Ribble Valley Borough Council
Housing & Development Control

Application no: **3/2021/0556**

Address: **74 Higher Road Longridge PR3 3SY and land to the rear**

Proposal: **Application for reserved matters consent (appearance, scale, landscaping and layout) pursuant to outline planning consent (ref 3/2016/1082) for the demolition of 74 Higher Road and construction of up to 123 houses on land to the rear.**

+ Drawing Title: **BOUNDARY TREATMENT DETAILS**

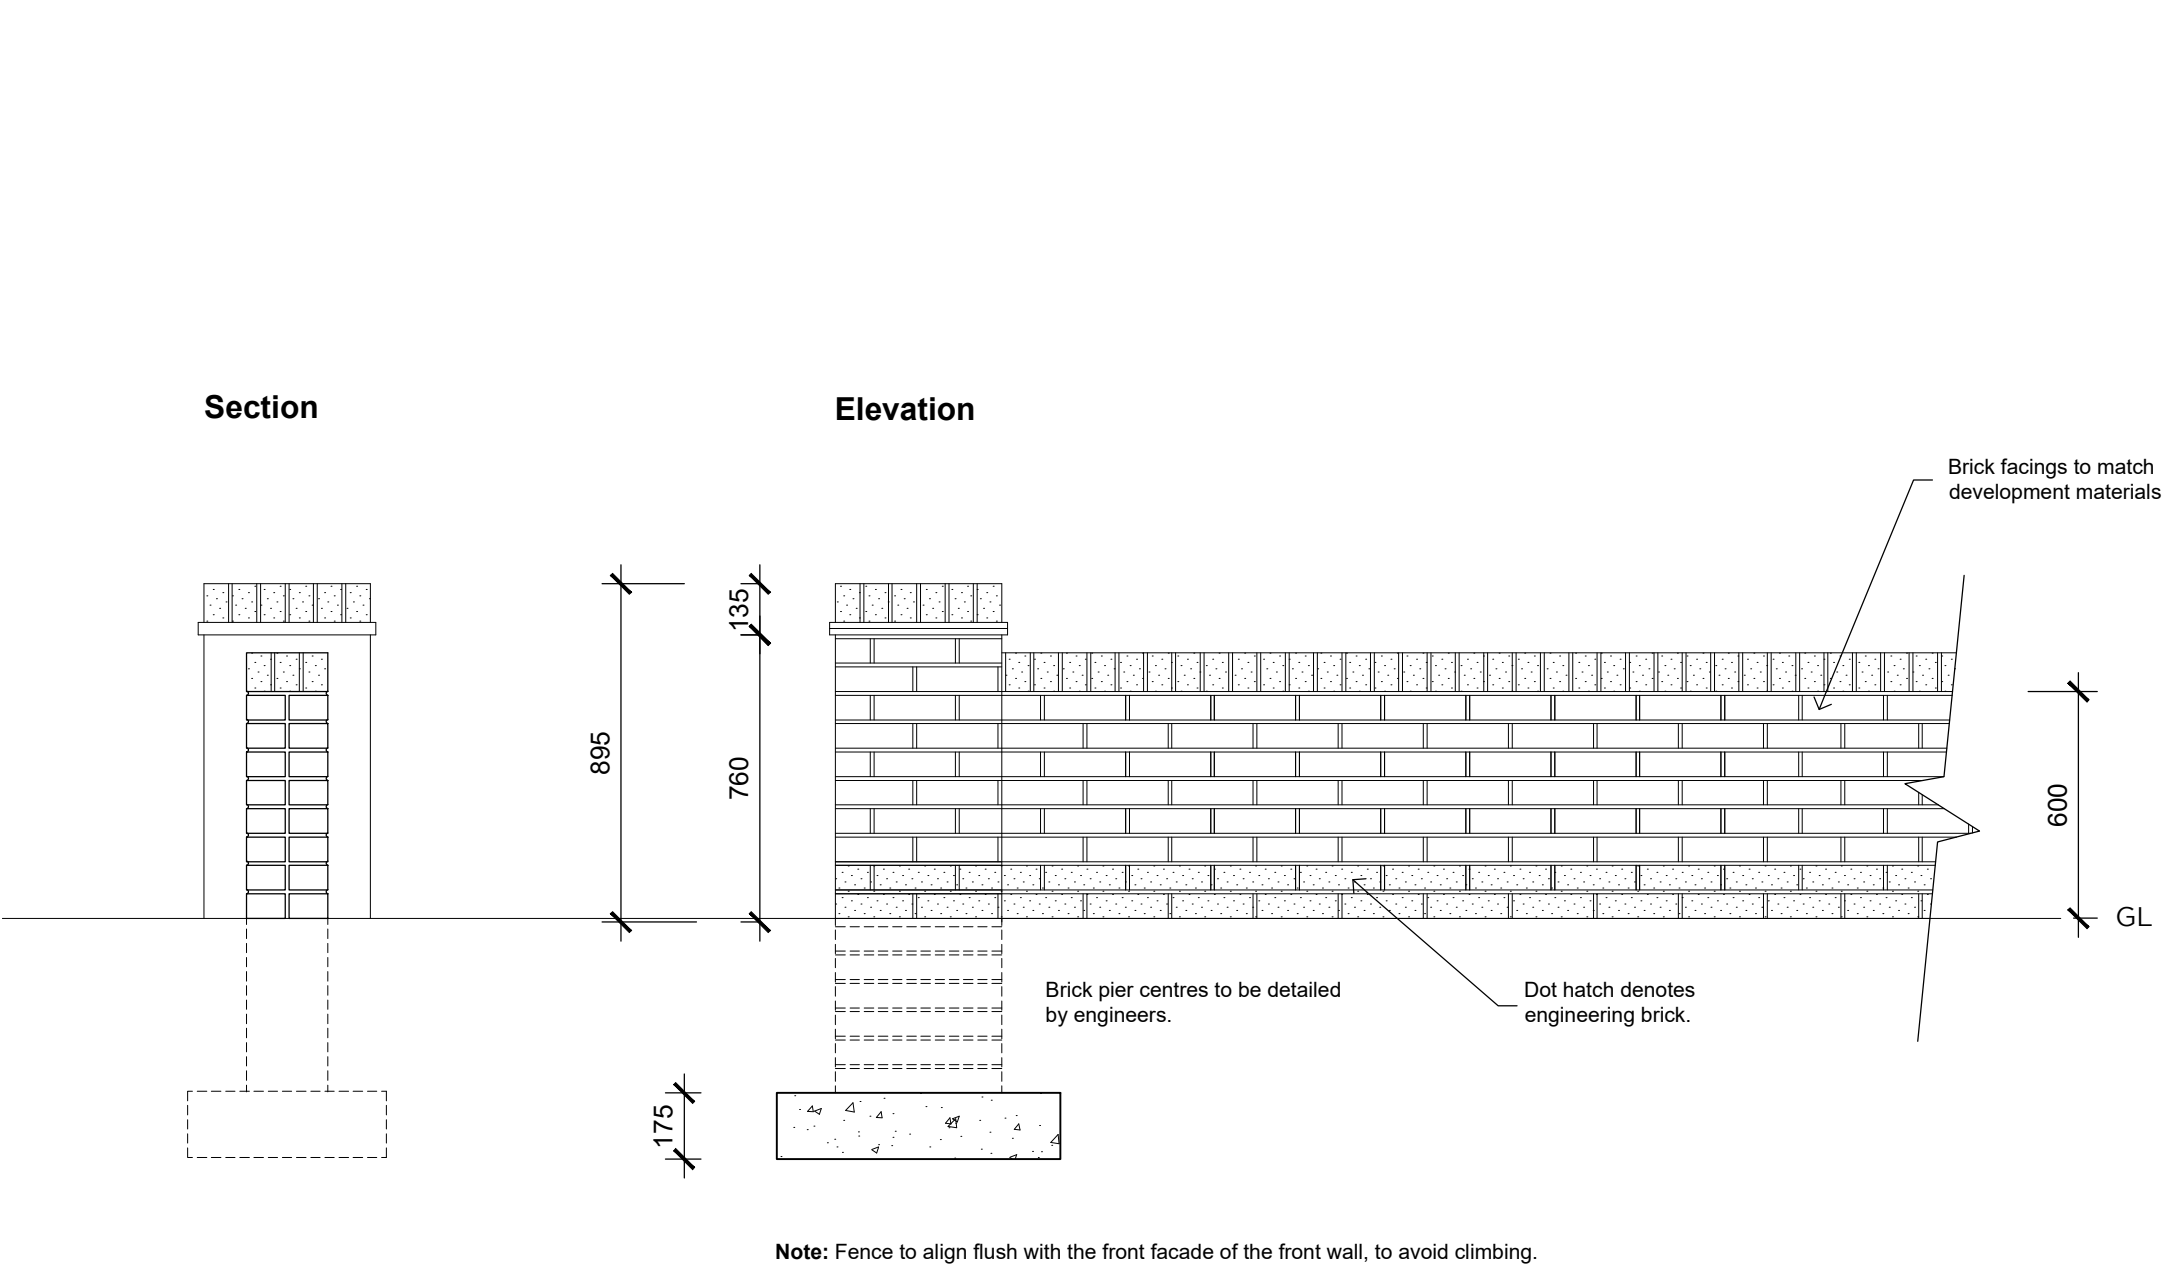
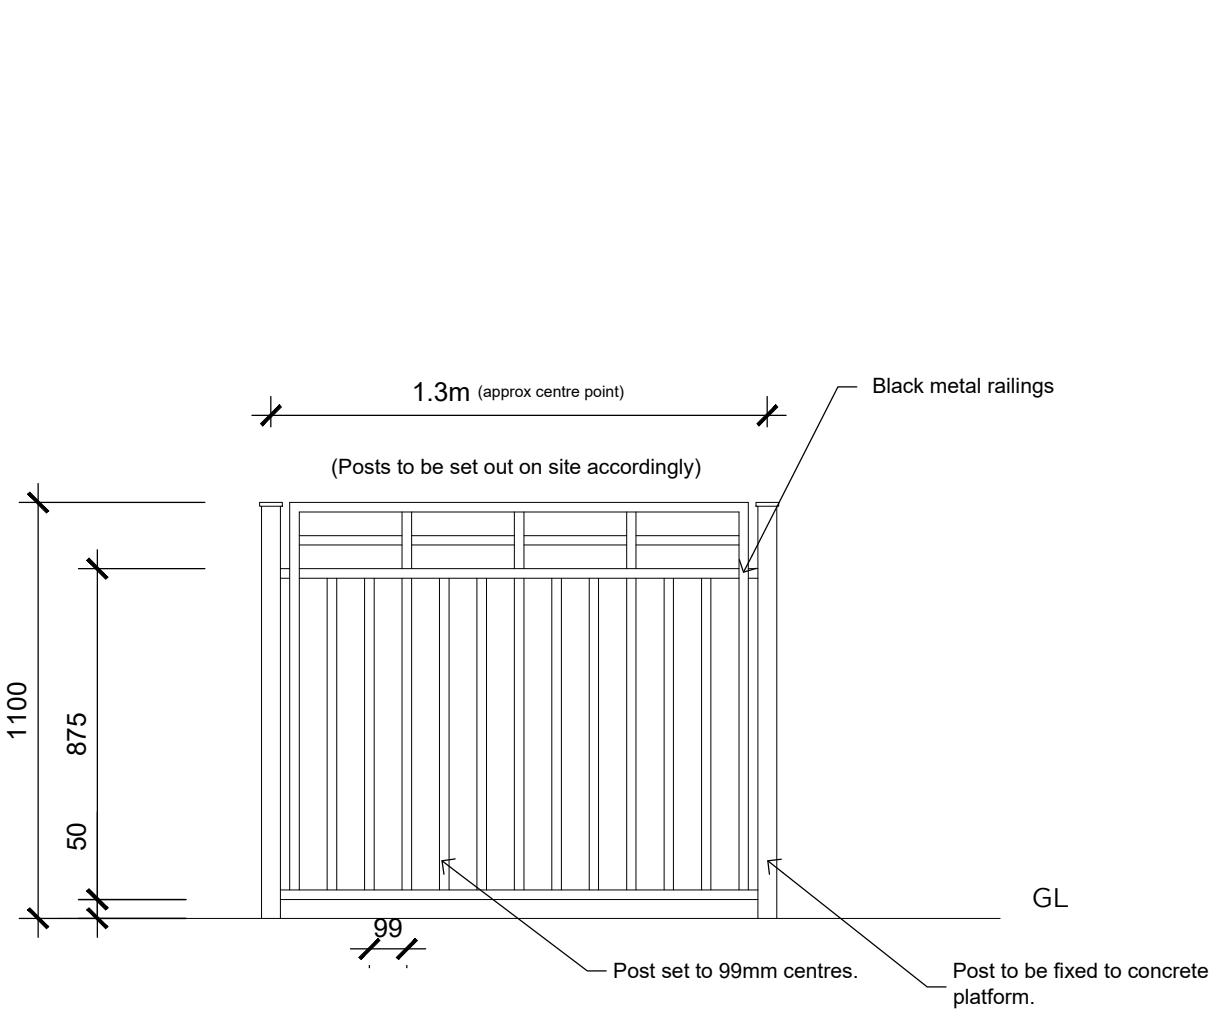
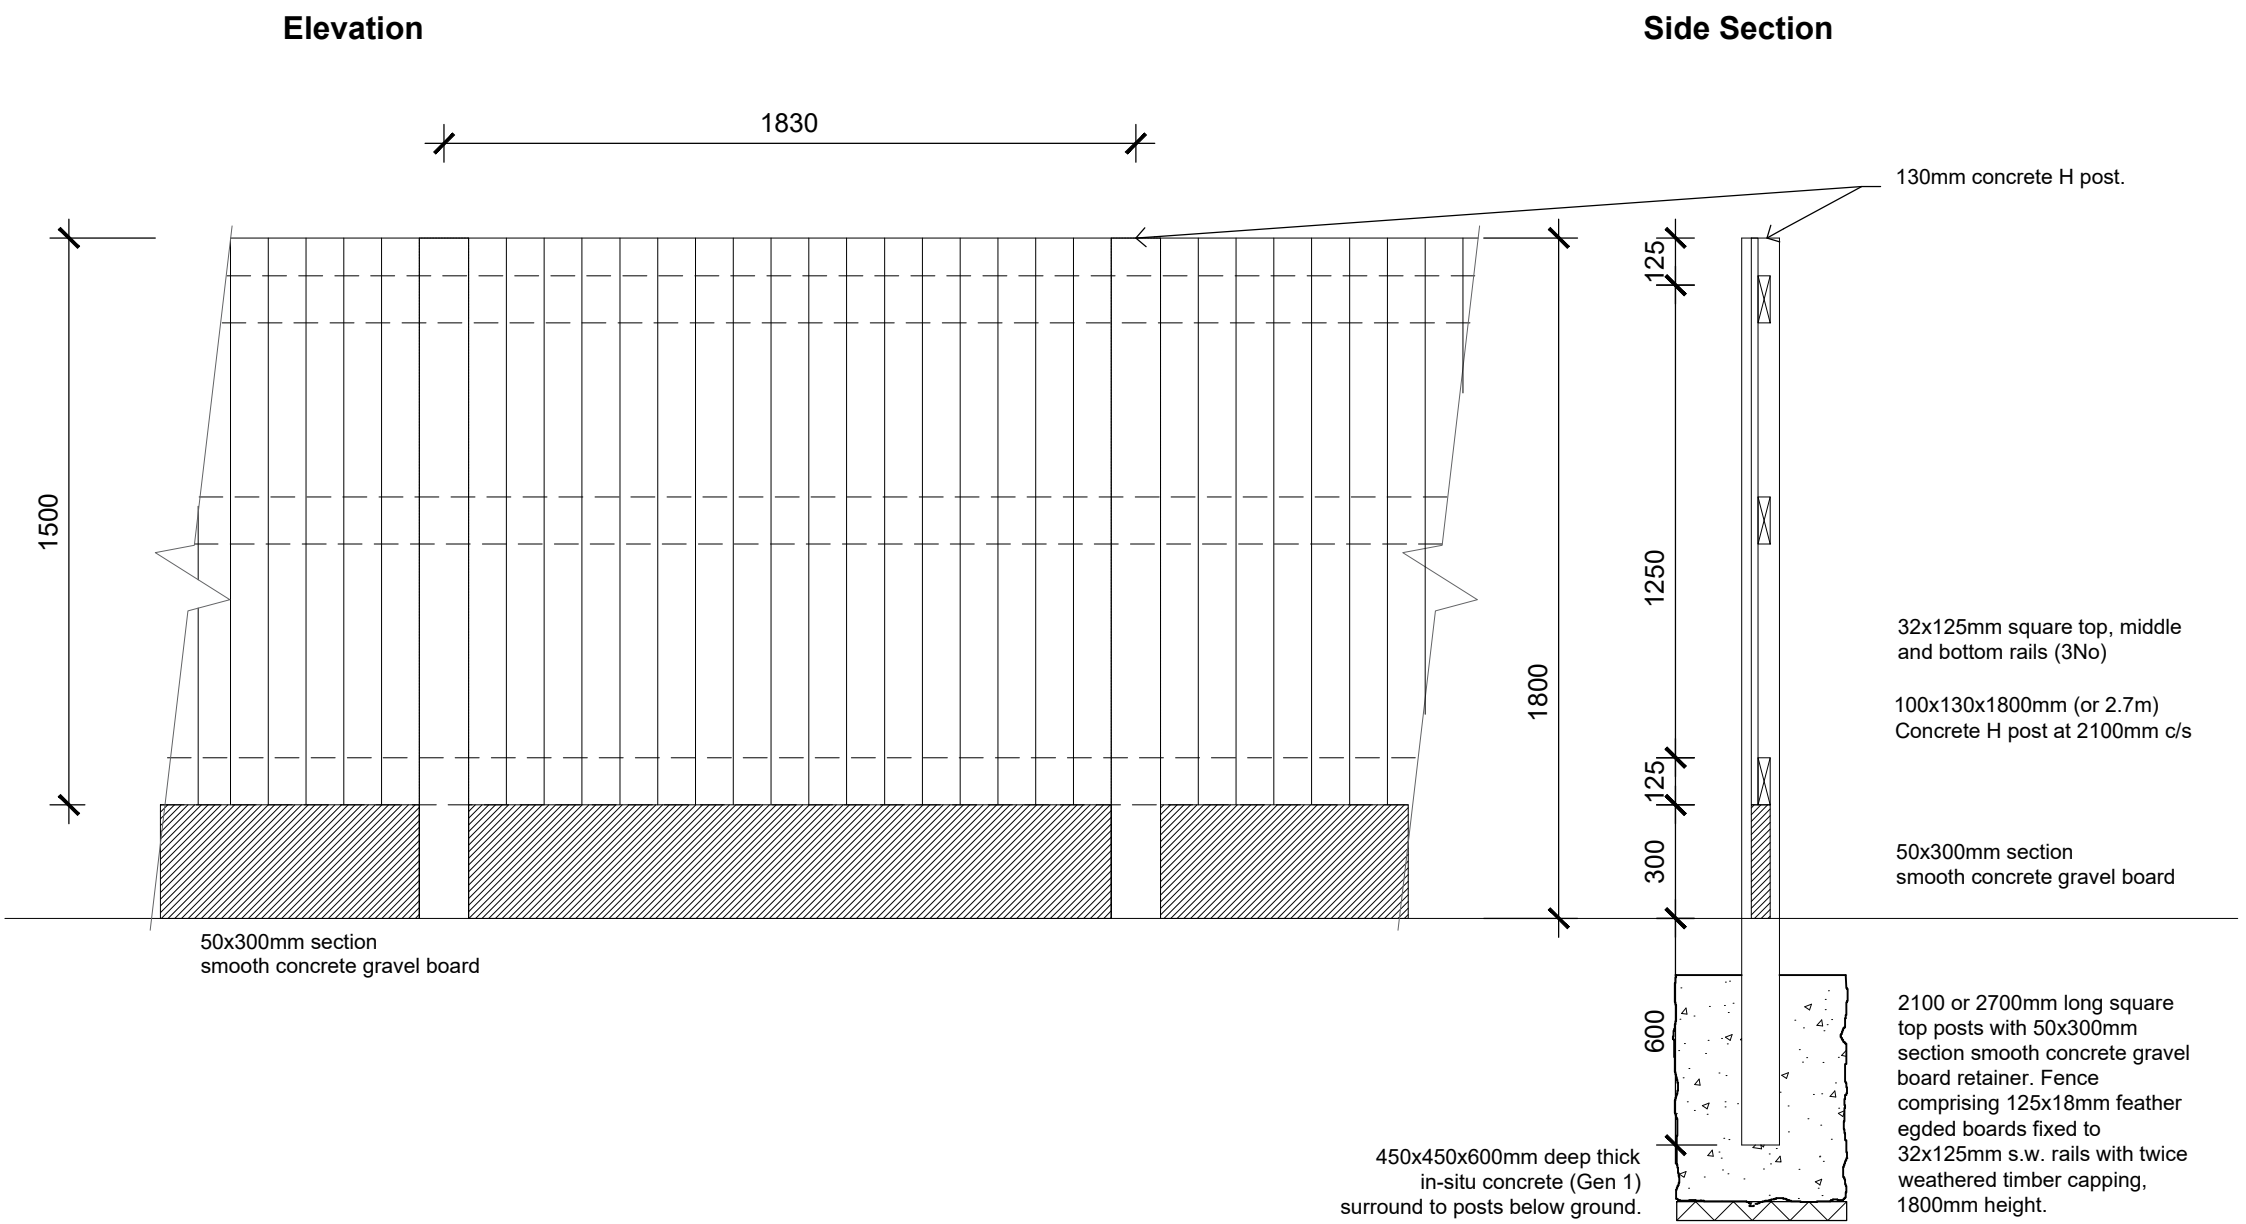
The LHA have also reviewed MPSL drawing number 03 Rev B titled "Boundary Treatment Layout" and require the 1.1m high railing provided at Plots 1, 2, 5, 6, 7, 8, 9, 10, 22 and 23 is reduced in height to 0.9m. The height should be reduced where the railing is located within each Plots visibility splay.
